SUBJECT: Engineering Review Comment  
Mountain View Electric Association Inc. (MVEA)

**Project Name: Armonia Ranch - Vacation Replat**

**Project Number: VR232**

**Description:** Proposed vacation/replat of Lots 6-14 located west of Goodson Rd. and Ayer Rd. in Township 12S, Range 65W, Section 14.

# ARMONIA RANCH VACATION PLAT

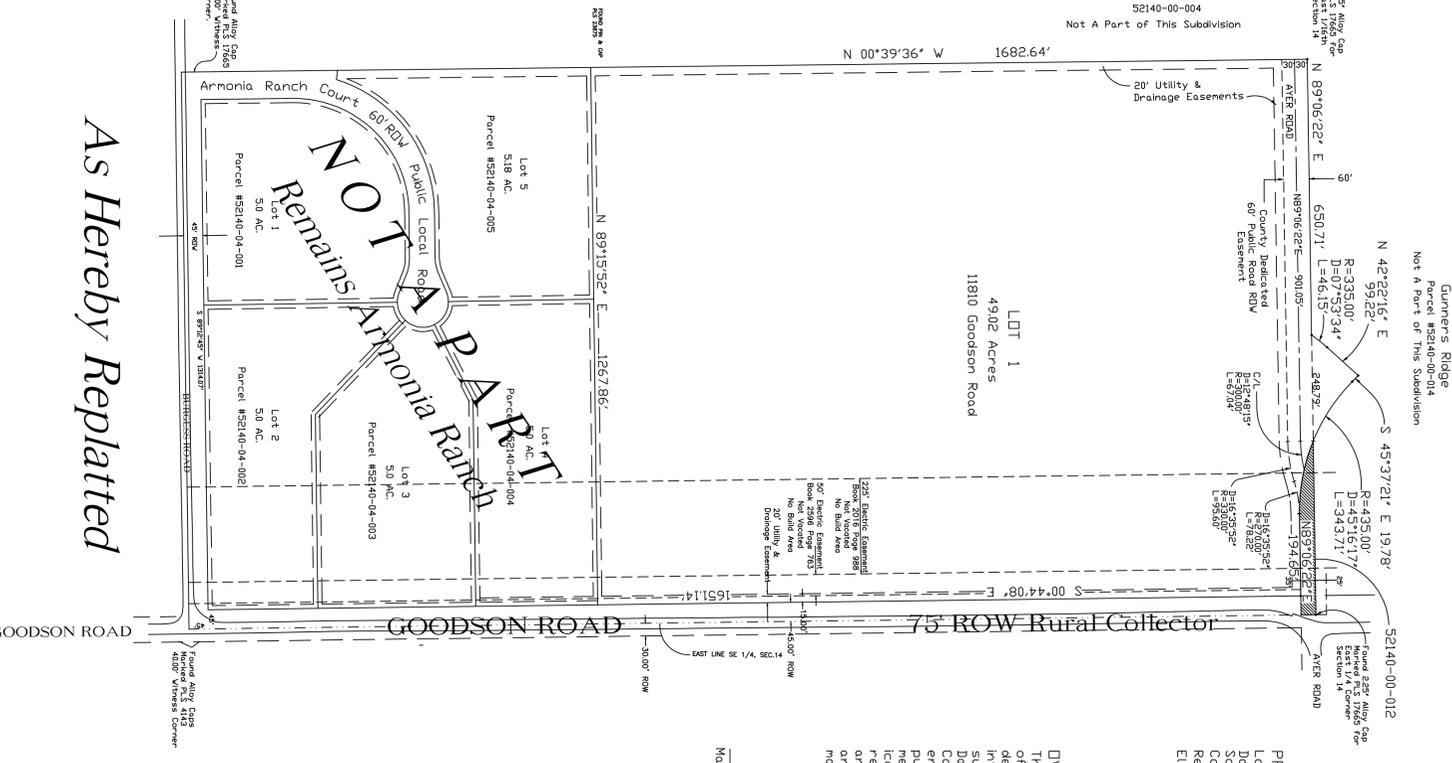
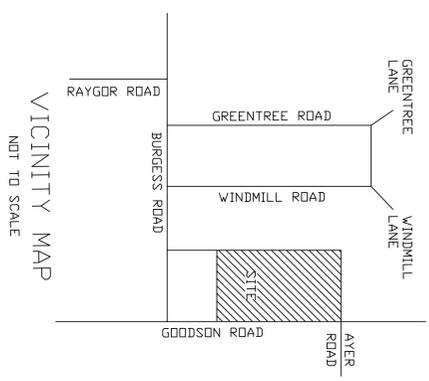
MVEA does not oppose the vacation and replat of the internal lot lines, however the 20' exterior boundary easement and all MVEA easements will remain. MVEA also requests the platting of MVEA's existing facilities with easements on the plat.
